DAVID MILLER, PE

RE: Engineering - Footing Extension
62 Progress Dr. ; Fuquay Varina, NC 27526 : Harnett County
Project No.:18DDM-1016I

1 WEST ELEVATION  
1/8" = 1'-0"

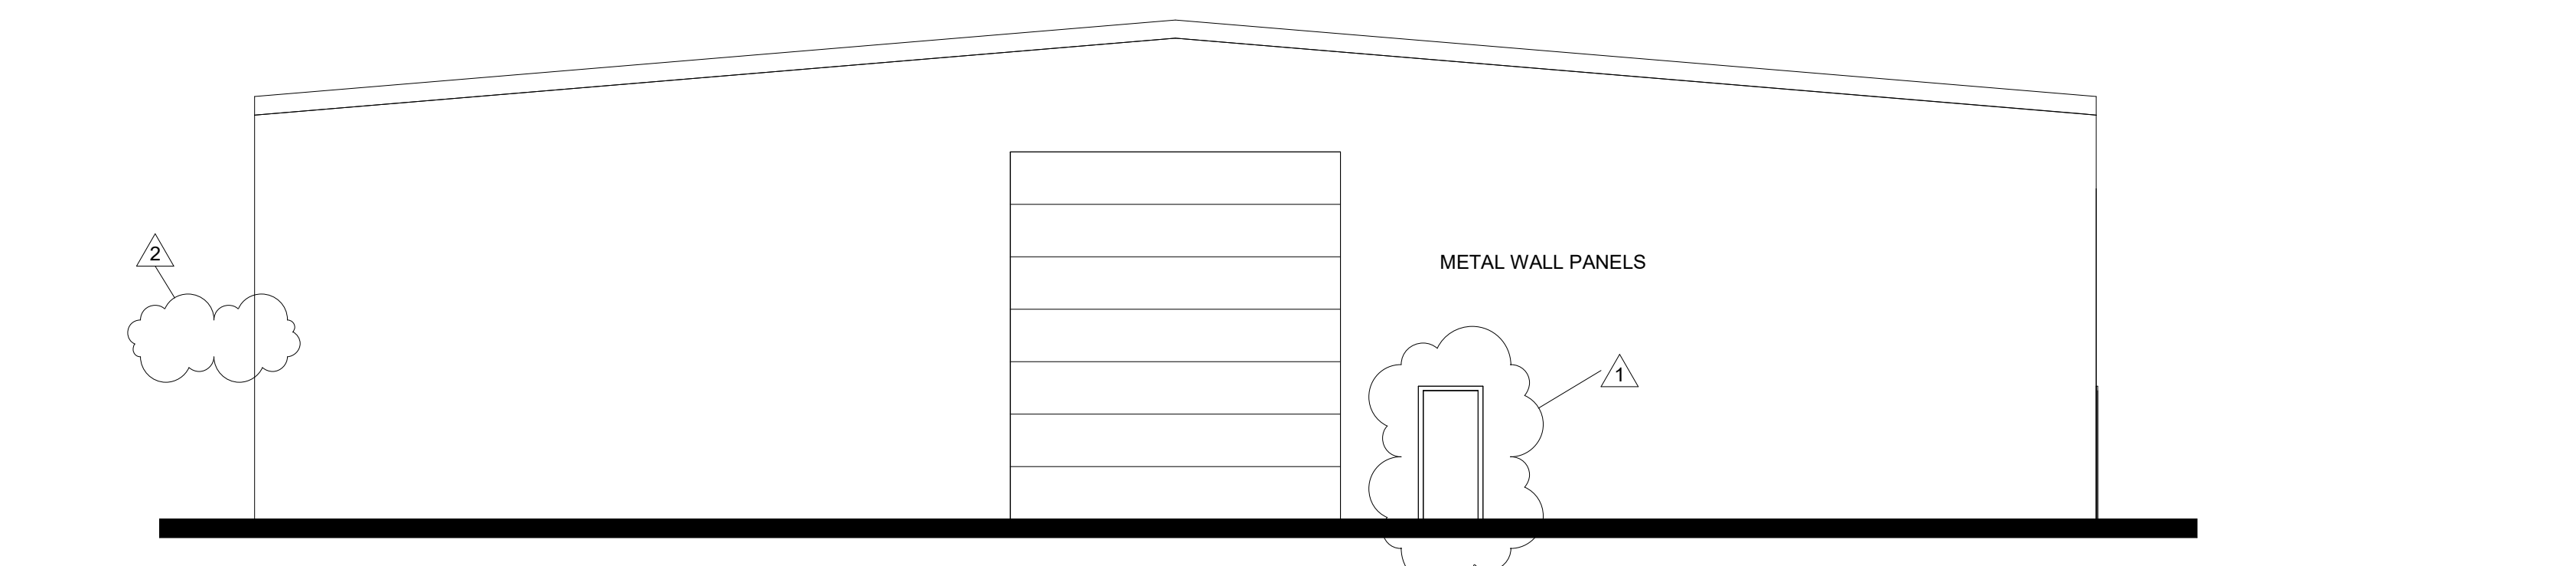
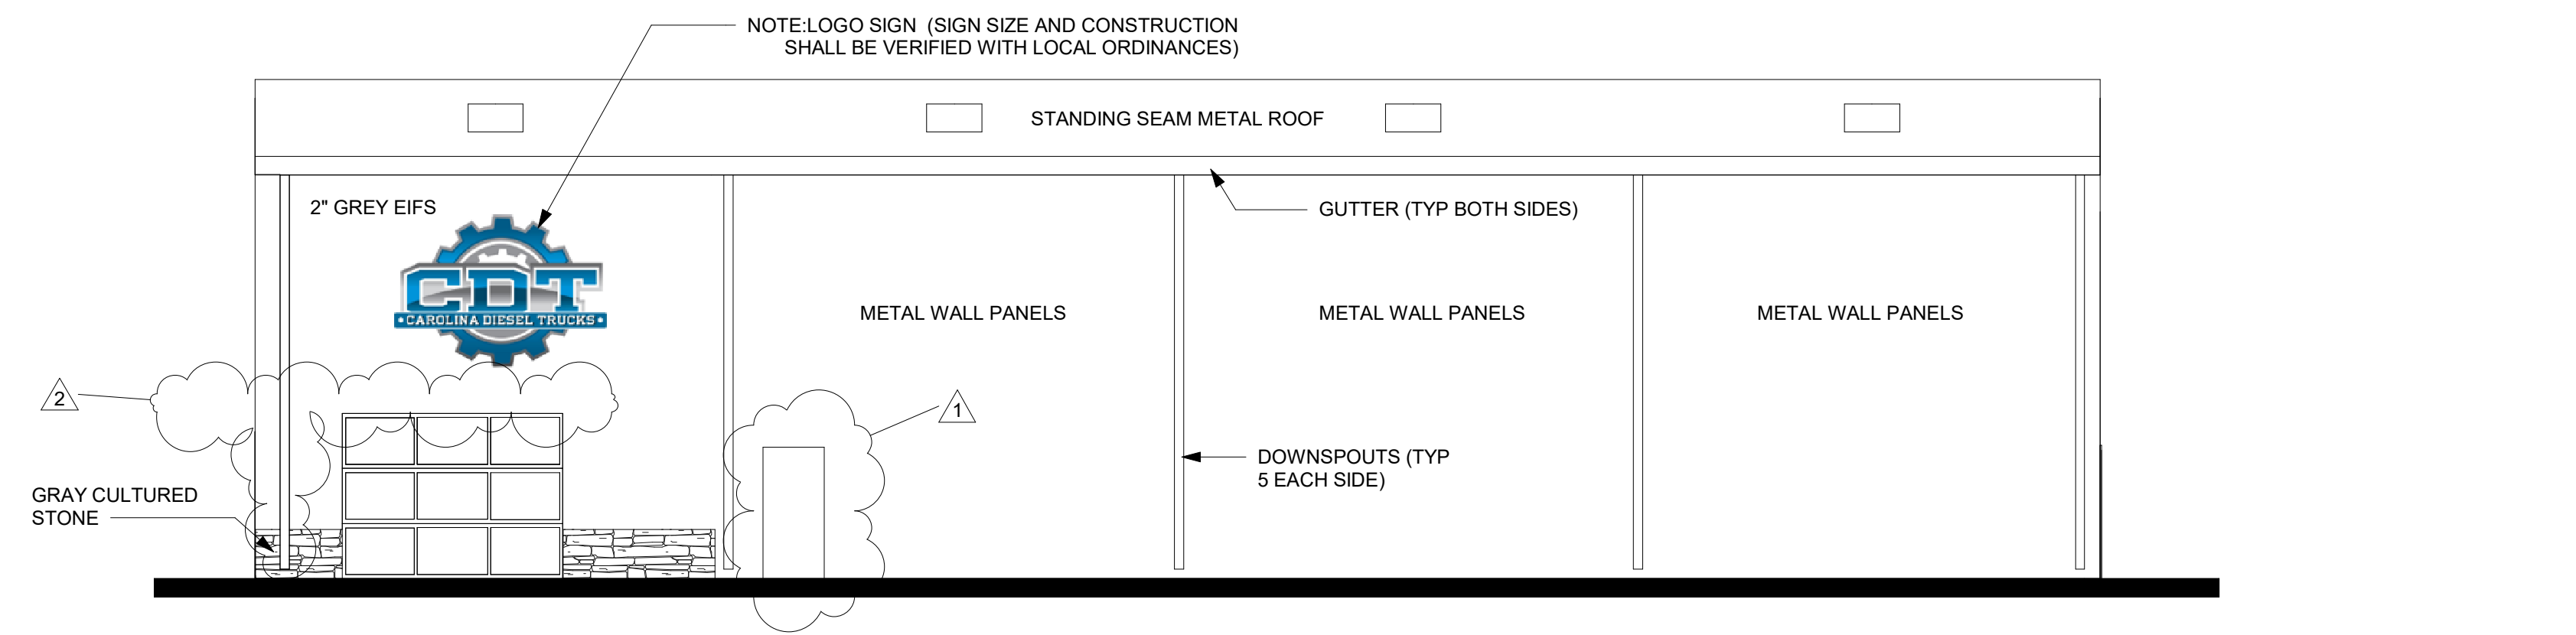
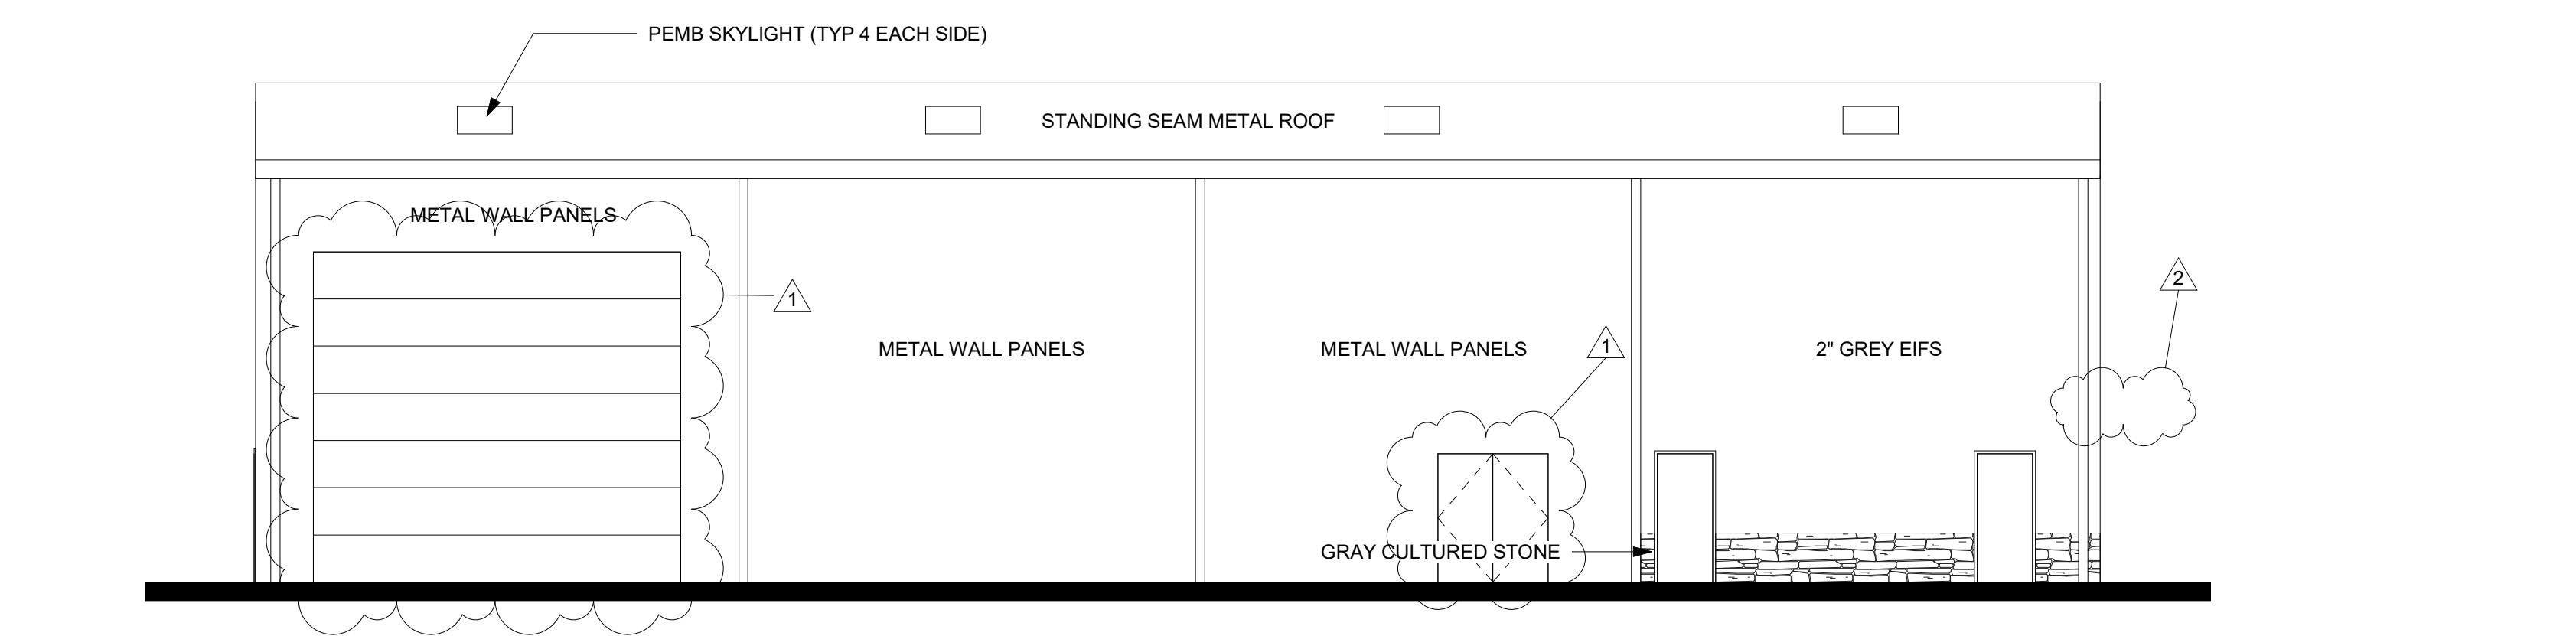
The undersigned arrived on-site previously and analyzed the following for the above referenced site. The front section of the concrete slab requires an extension to support the window front and based on the analysis an extension (full depth) at least 6 inches with two dowelled #4 reinforcing steel bars no greater than 16" c/c should be added to allow the concrete slab extension to adequately transfer and support the planned loading conditions.
